Property: 6-16 Atchison Street, St Leonards

**Proposal: Section 75W Modification to allow an additional 4 levels to an approved
Mixed Use Development**

MODIFICATION REQUEST – SECTION 75W MODIFICATION TO MIXED USE DEVELOPMENT AT 6-16 ATCHISON ST, ST LEONARDS (MO-09_0187 MOD 3)

NORTH SOUTH SECTION

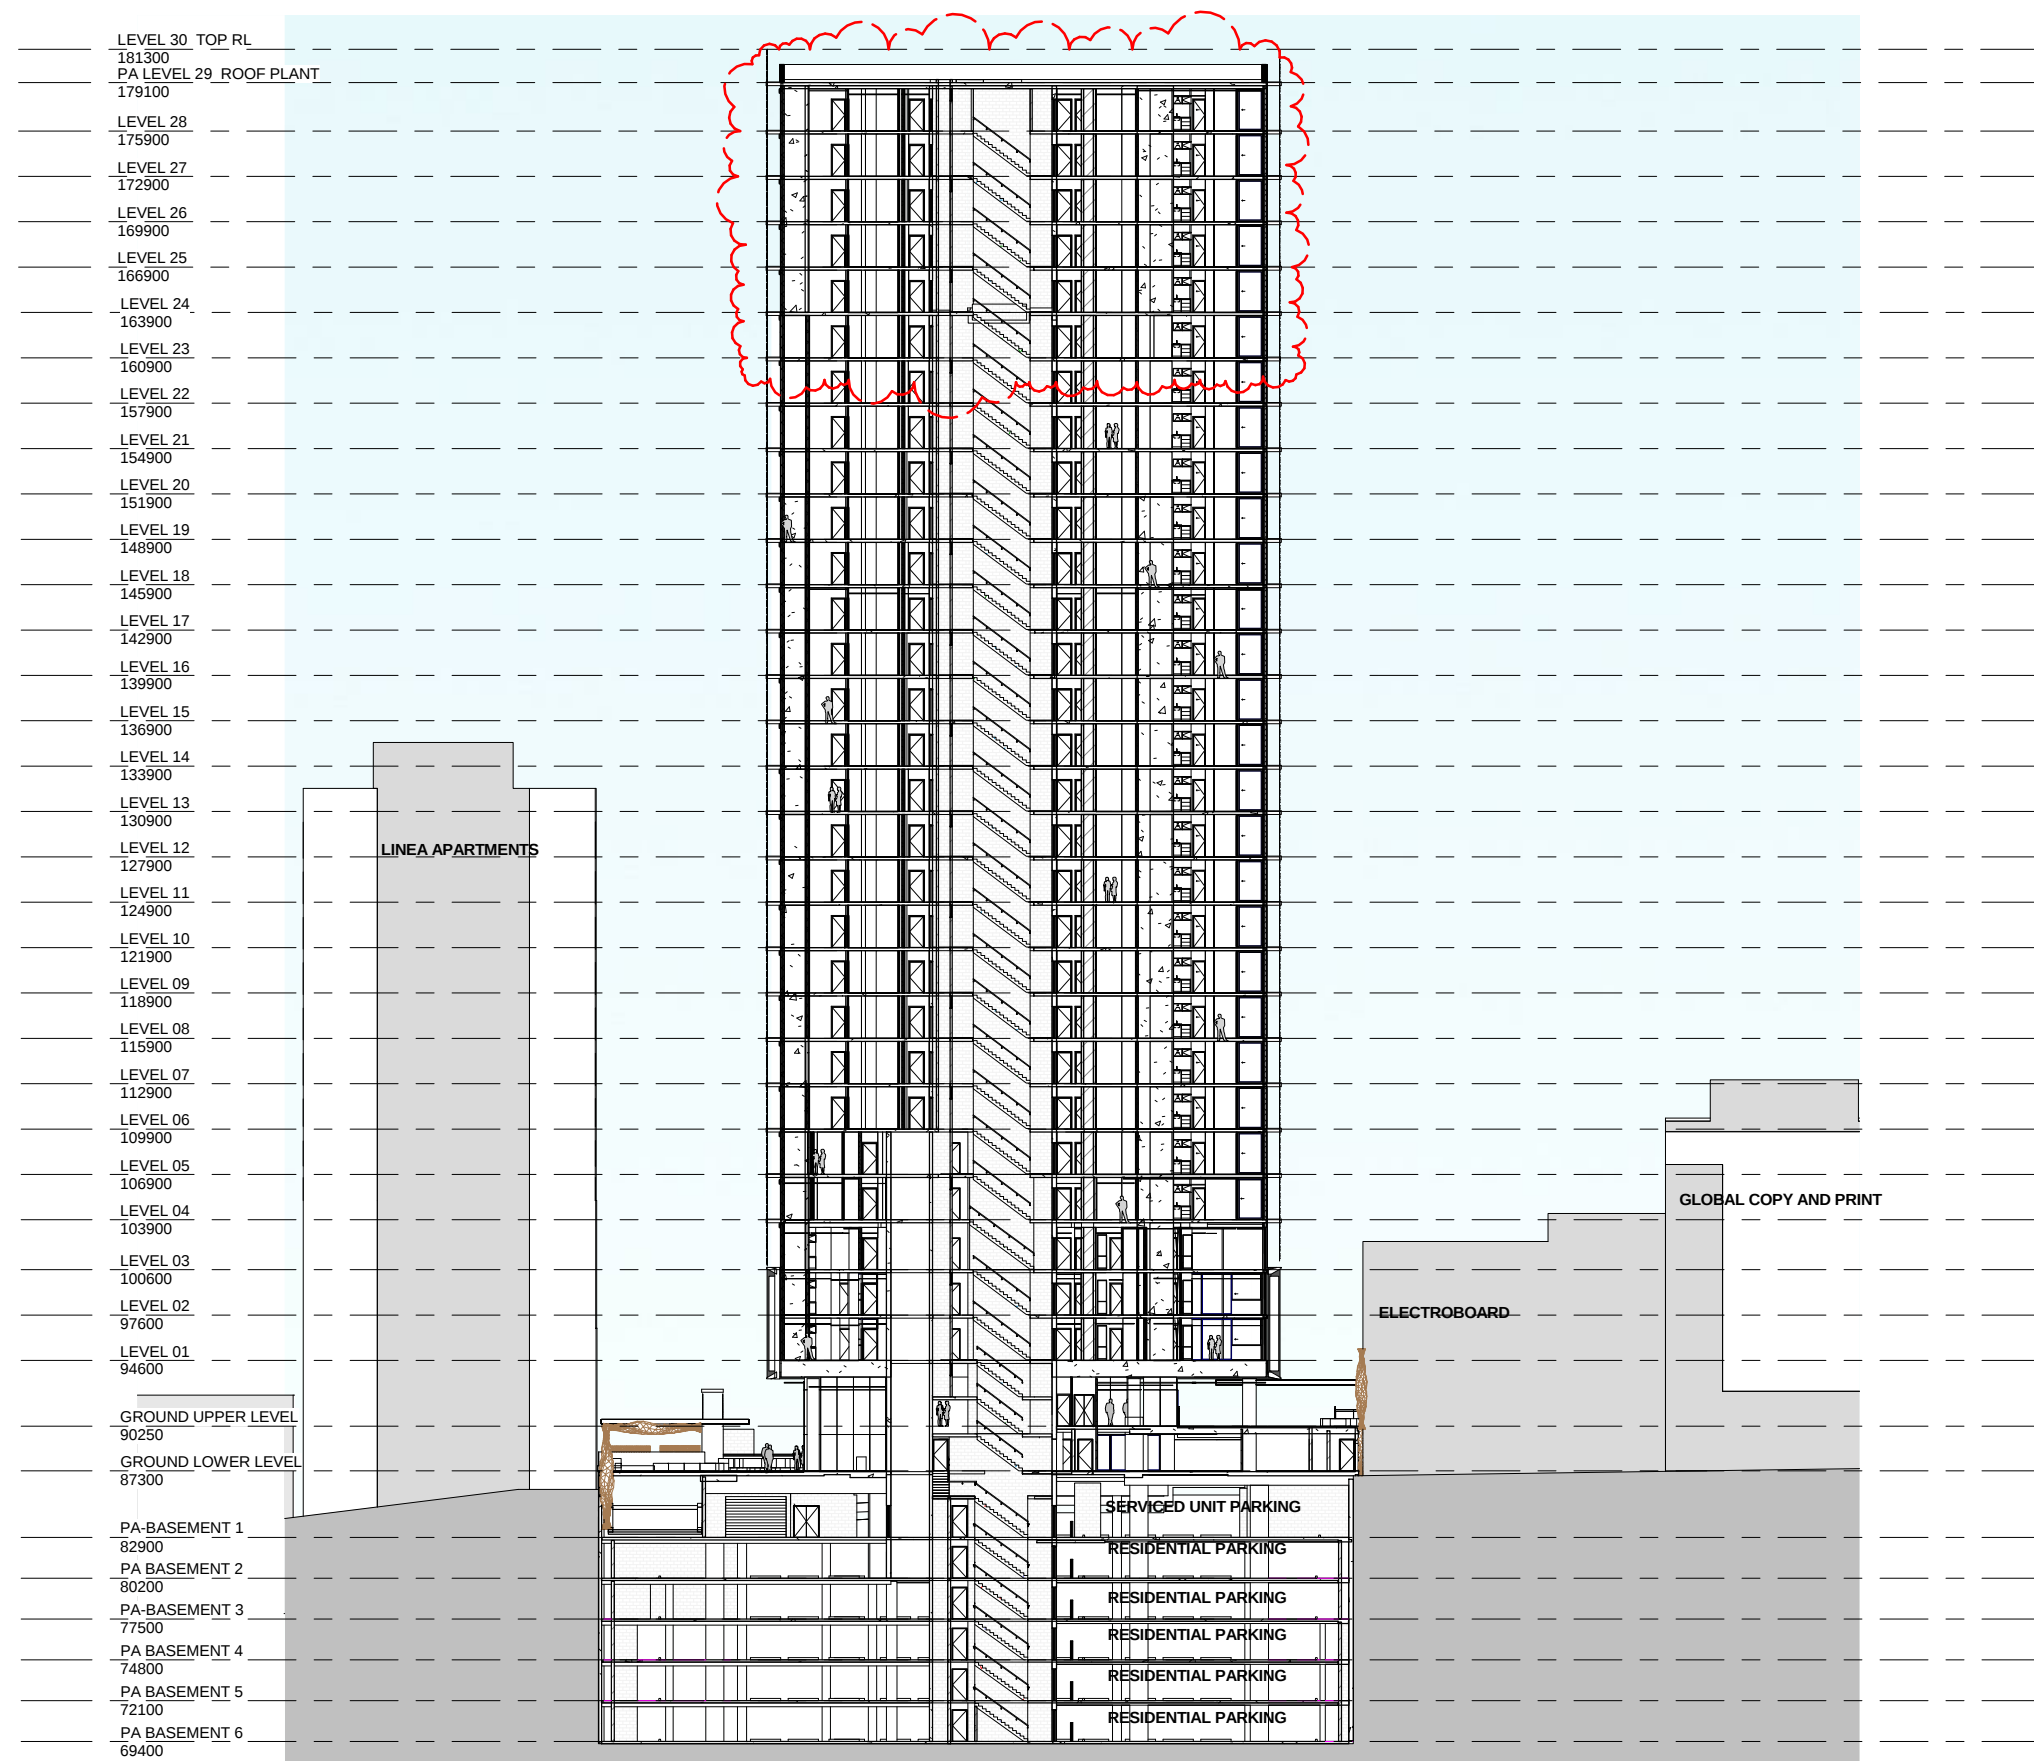
The proposed additional building height to be increased from RL167.3m (82.5m) to RL 181.3m (94m) AHD is strongly opposed. The North Sydney LEP 2013 sets a maximum Building Height of 49m on the site. Council strongly opposed the approved building height and form at the time. The proposed modification is seeking to reinstate an additional 4 levels that were previously refused by the Planning and Assessment Commission as part of the original development consent. This additional height continues to be without merit and should not be supported. The approval as it stands is considered to have compromised the orderly development of land in St Leonards.

The proposal fails to provide a clear understanding of the proposed height in relation to the local context. Tables comparing the proposal to other buildings combine data in storeys, RLs and metres which does not provide an accurate assessment of the proposed height against the local context, including The Forum. Similarly, the section diagrams are schematic at best.

BASEMENT Level 1

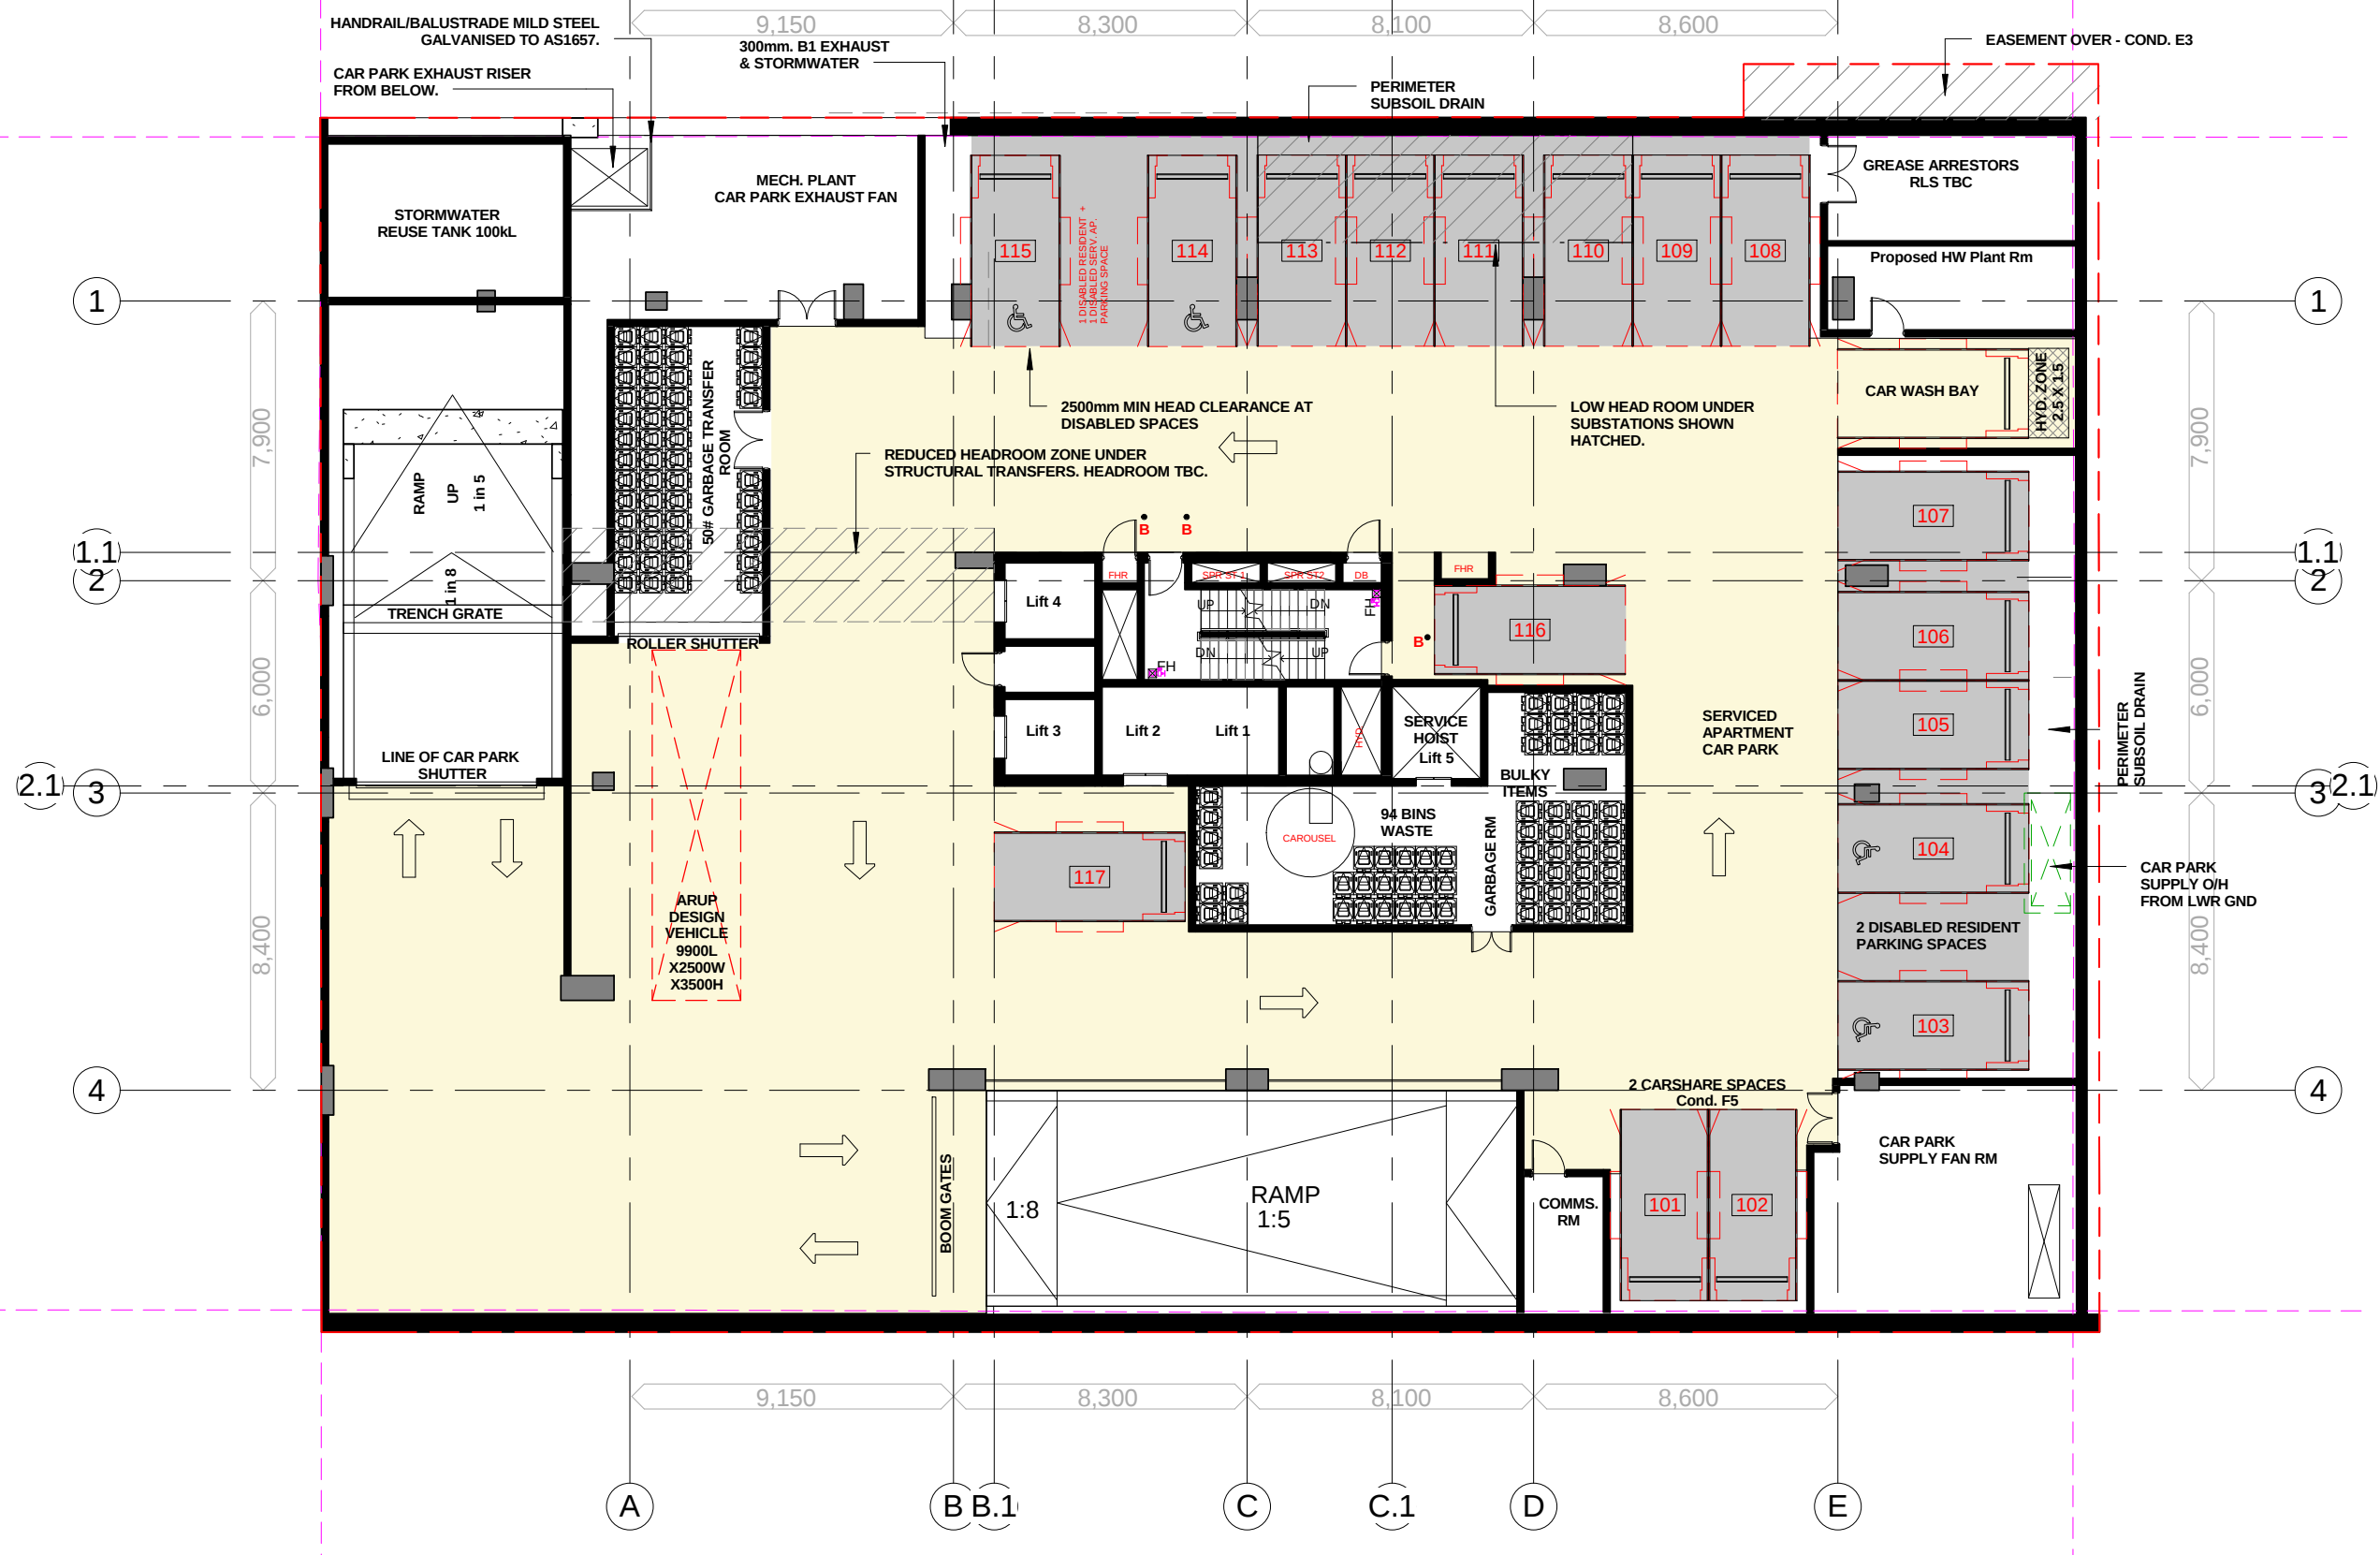
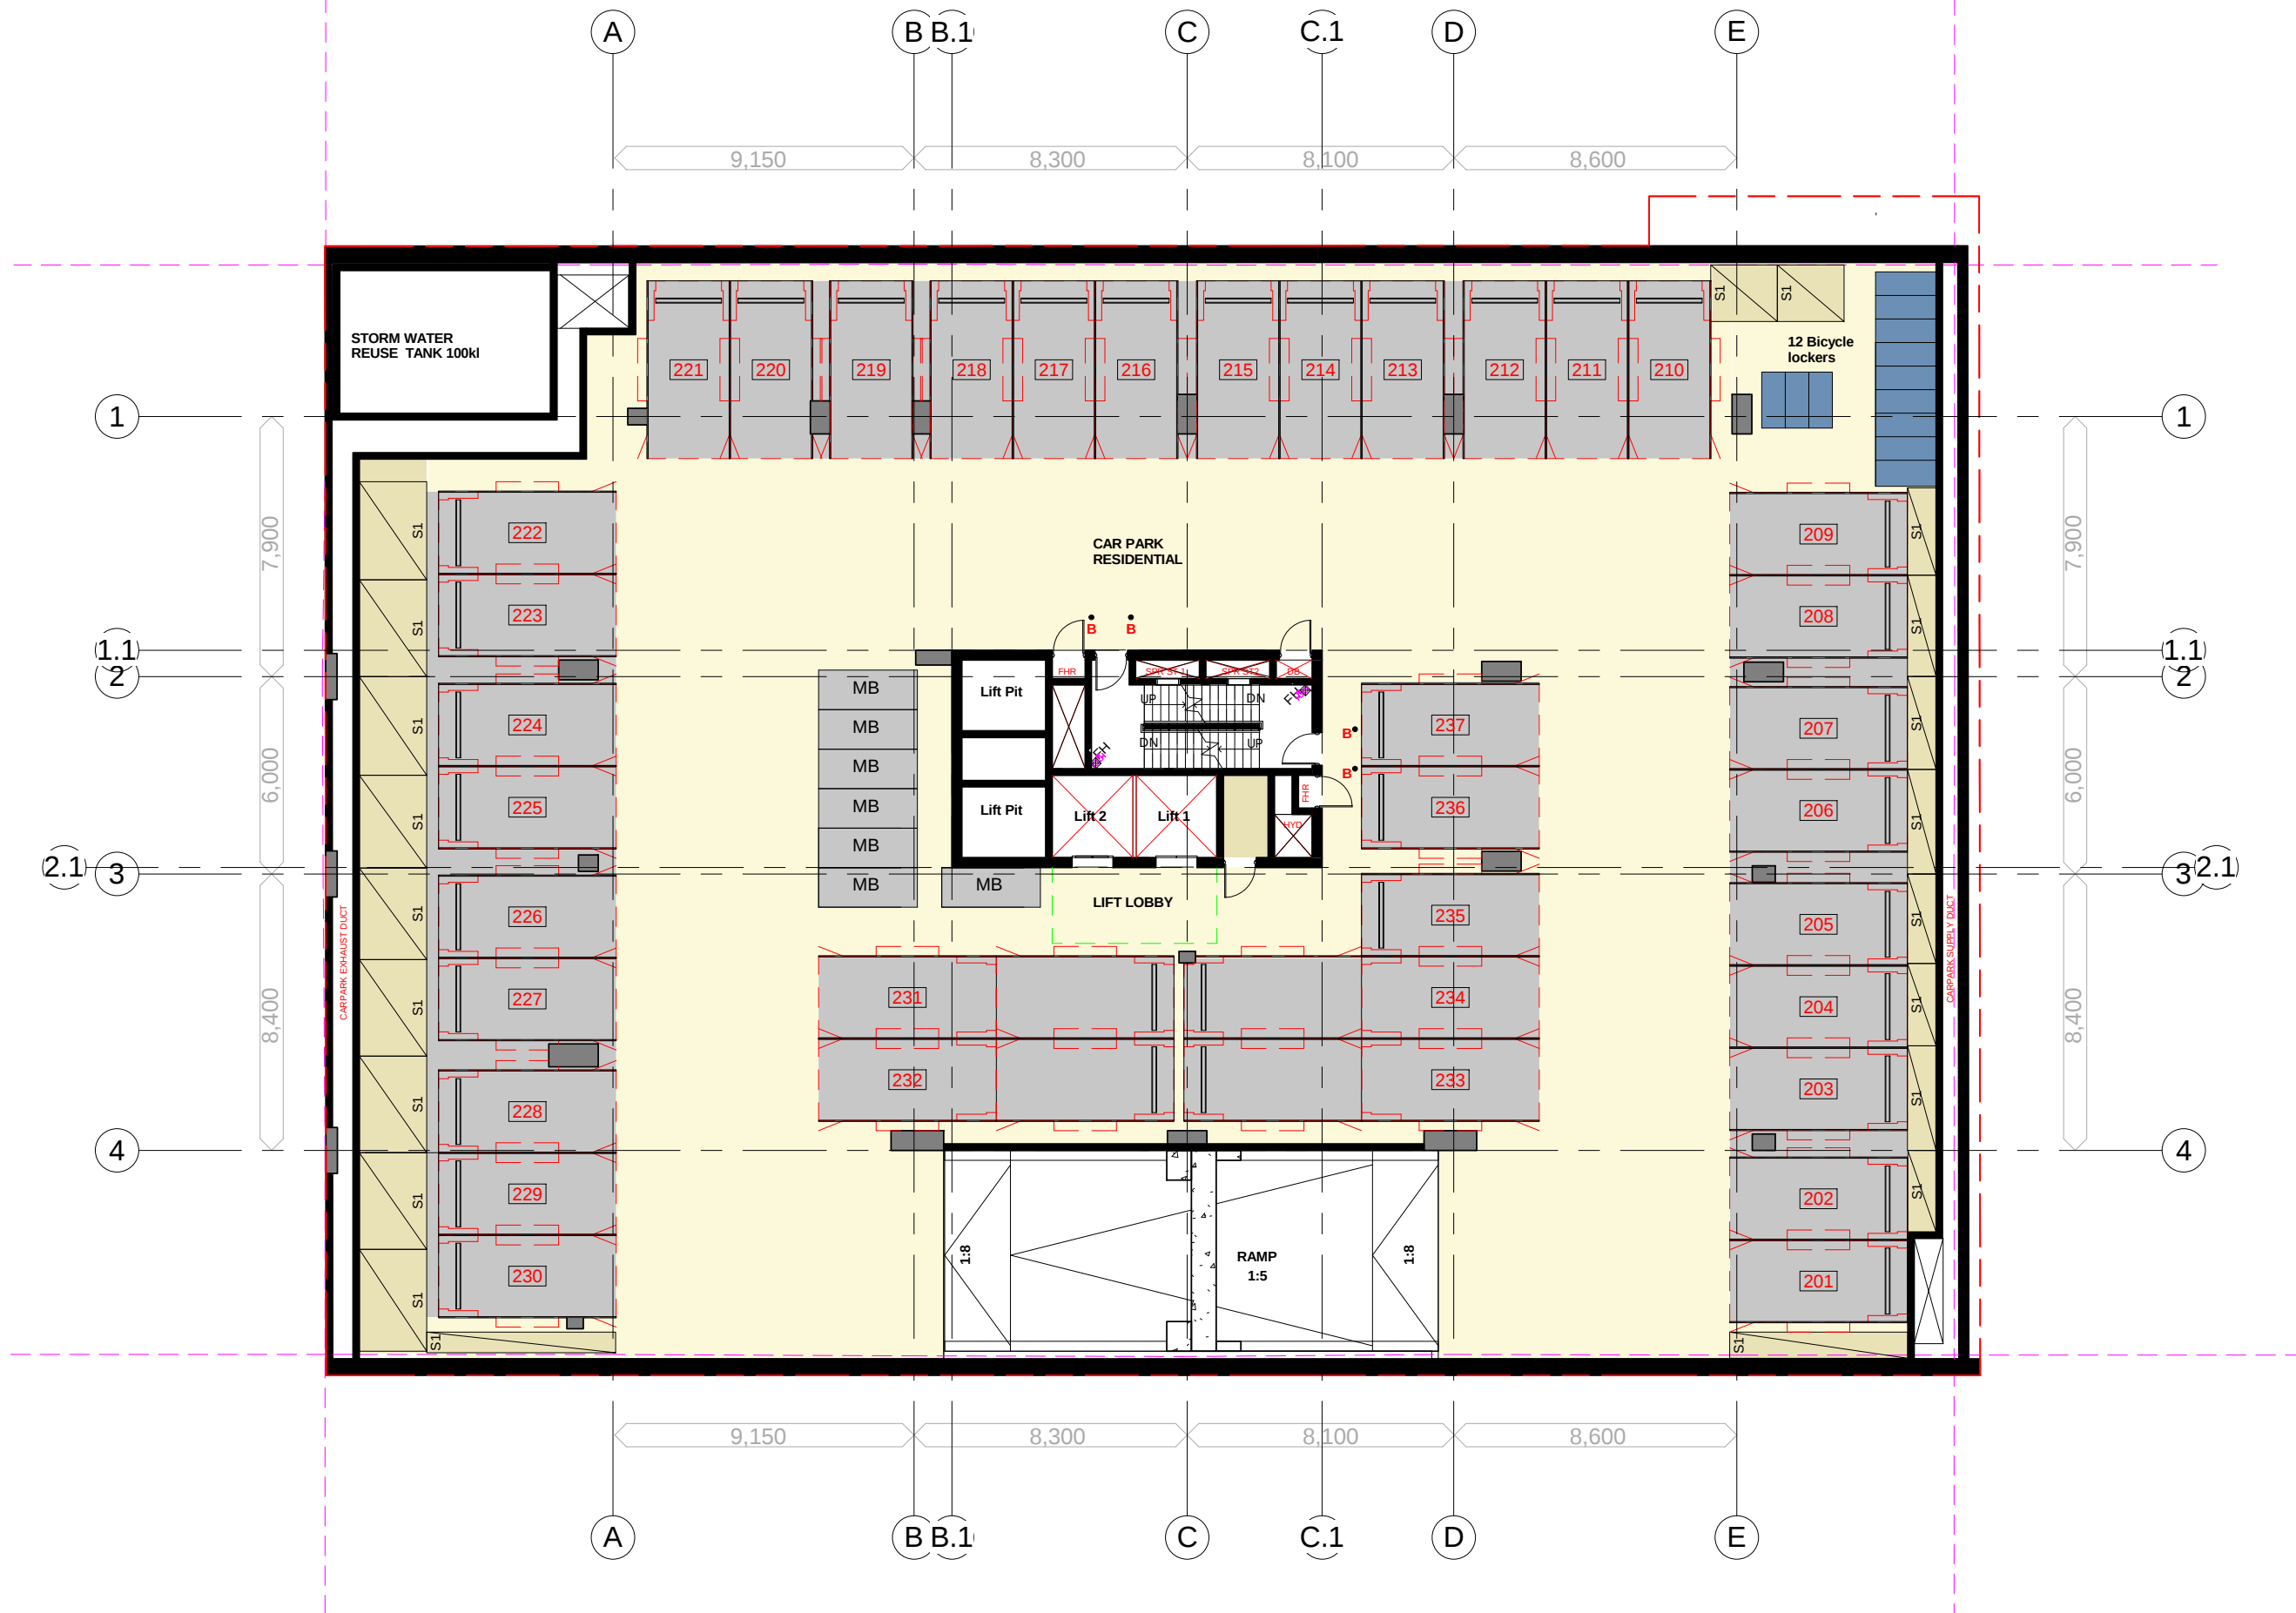
In addition, the modification proposes to provide an additional 34 car parking spaces within the approved 6 basement levels. Concern is raised that the basement has been already approved to accommodate this quantum of additional car parking that has not yet been approved.
